14 December 2022

**Sydney Olympic Park Metro Station - Over & Adjacent Station Development
(SSD-35283699)
Site 4B - Fitzpatrick Investments P/L**

THE AVENUE, SITE 4B
 10 HERB ELLIOT AVE
 SYDNEY OLYMPIC PARK
 BASEMENT B2 PLAN

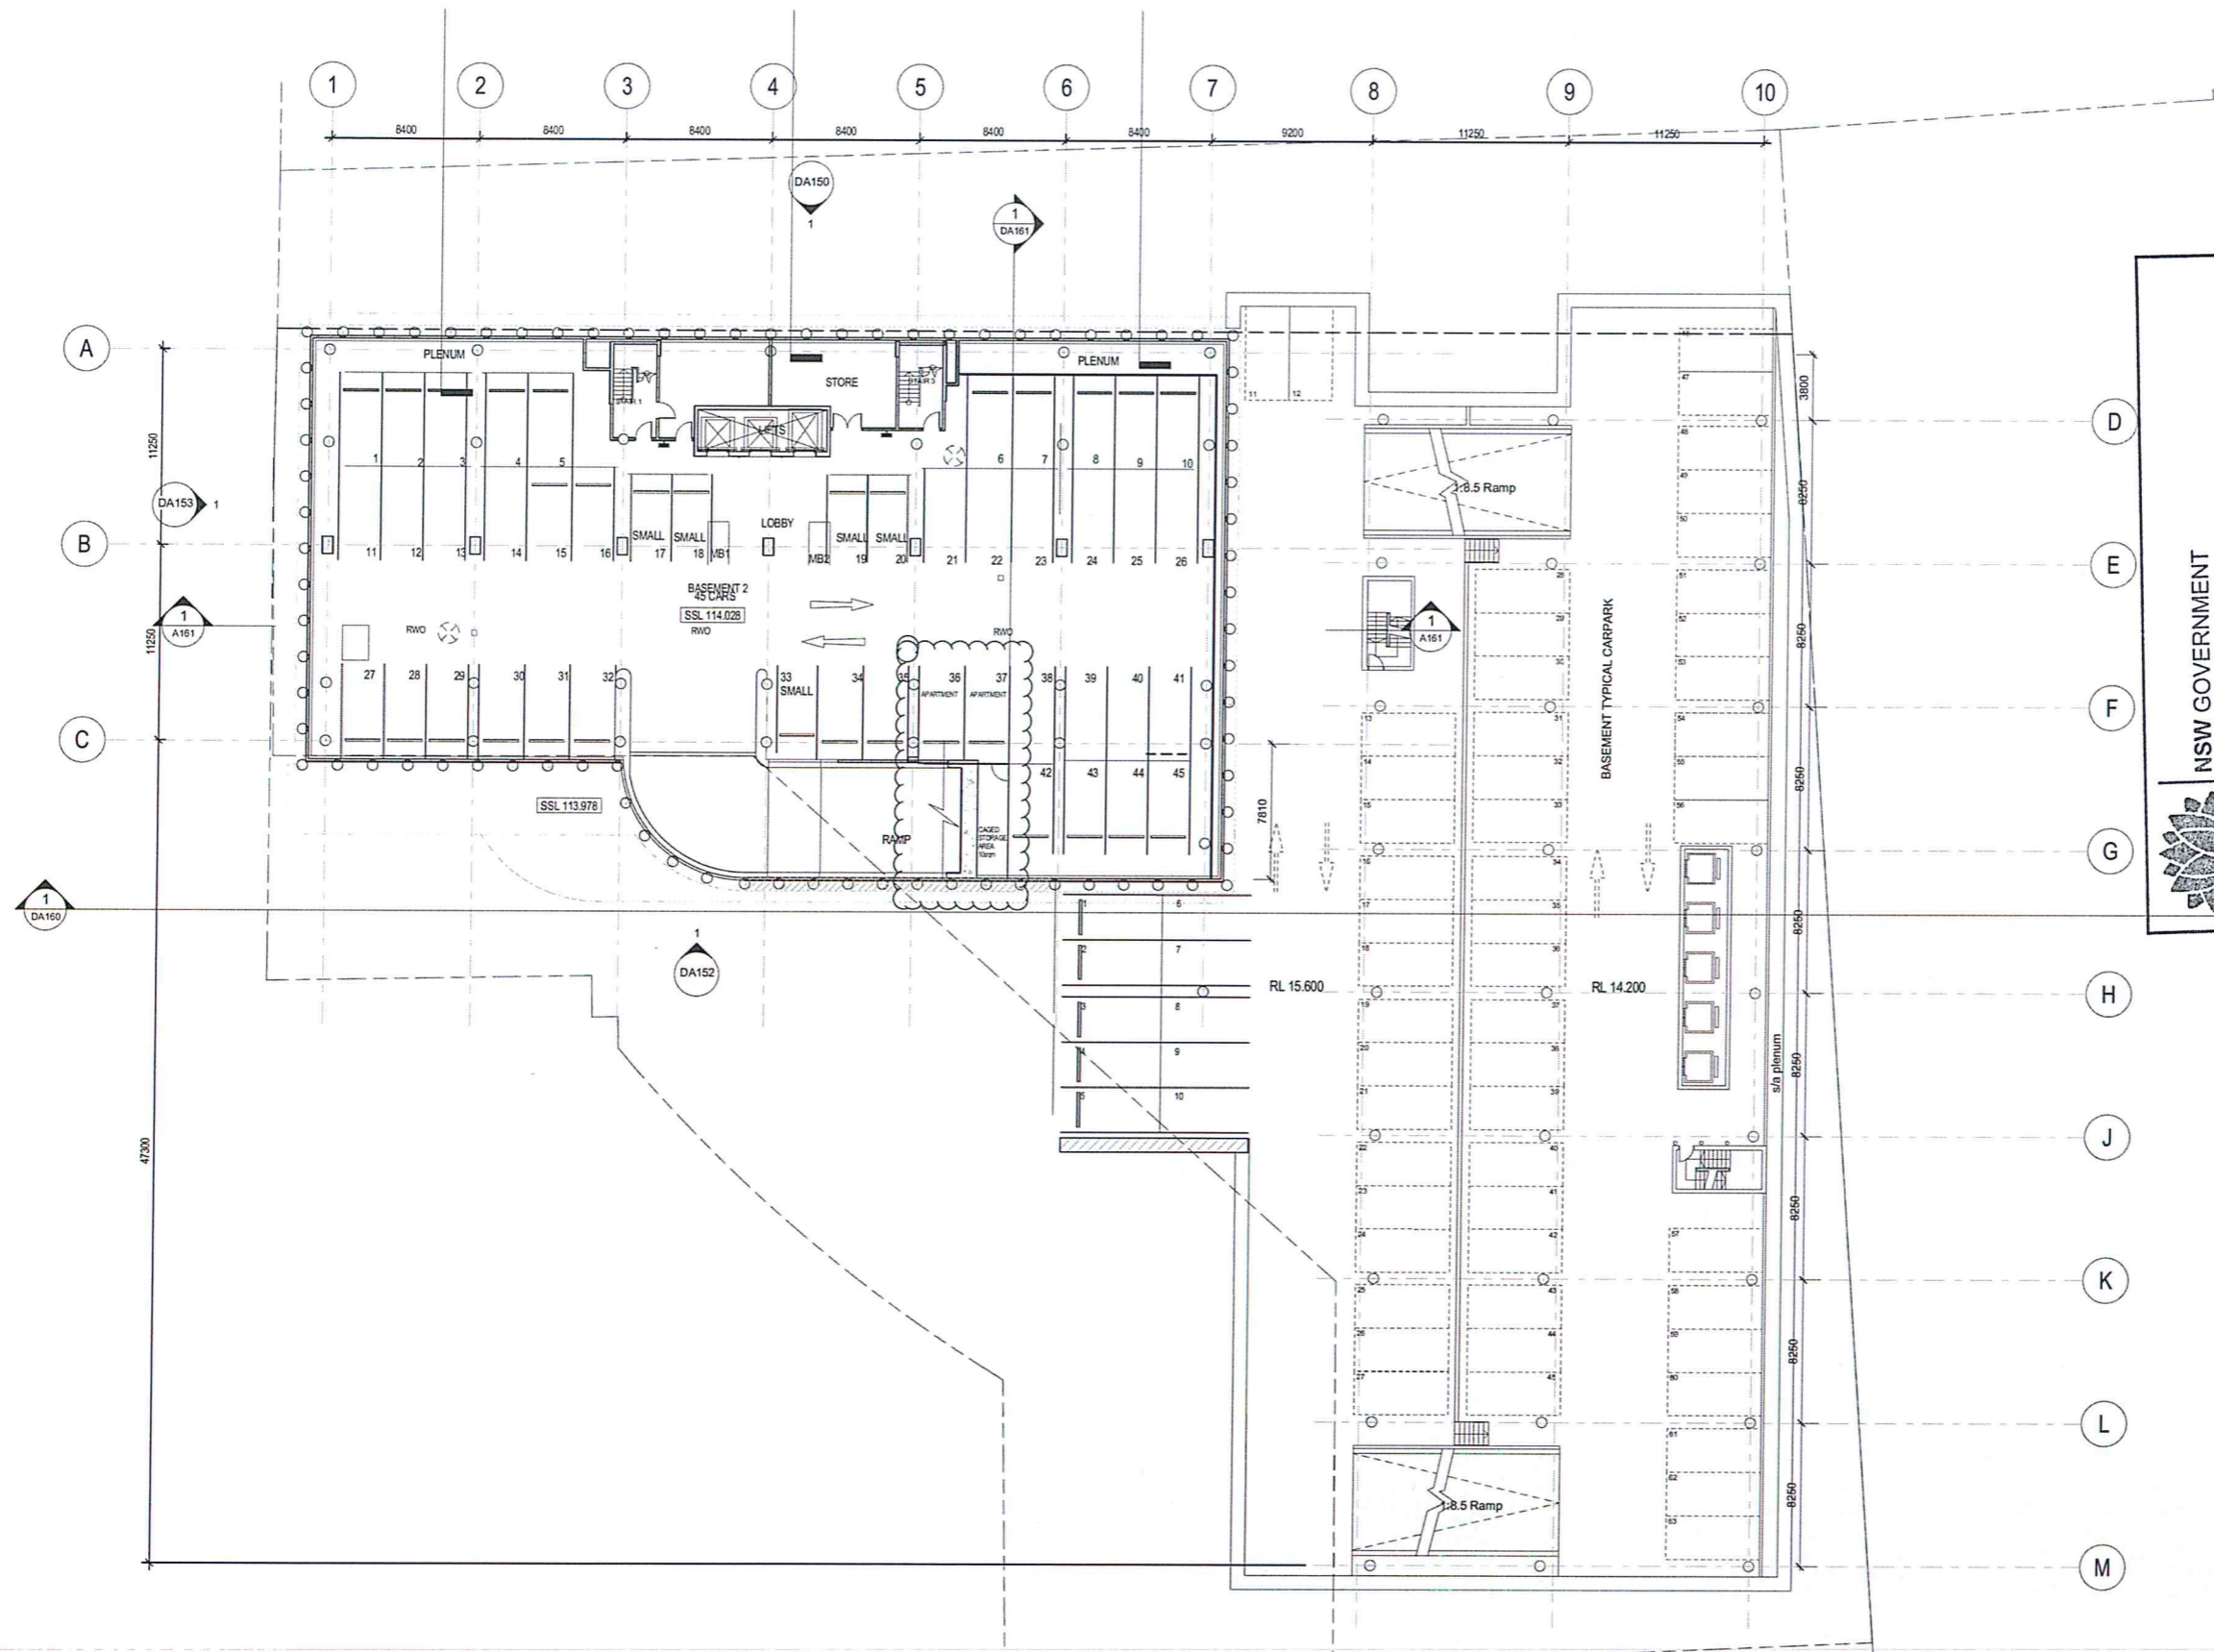
Attached is a copy of the approved DA for Site 4B (MP 06-0273). The design (in term of levels, turning circles and pavement treatment) needs to take into account the current basement access to Site 4B as well as the adjacent loading dock. This loading dock is sized for the 10 storey commercial building. Allowance should be made for a larger dock that would cater for a larger, mixed use development as envisaged under the SOPA Masterplan, especially if active retail / F&B uses is to be provided at ground level fronting the future 'Miluni West End' Plaza.

As per our previous submission on the SOPA Masterplan, we seek assurance that vehicle access to Site 4B, for deliveries, residents and workers will be maintained 24 hours, 7 days per week inclusive of event mode.
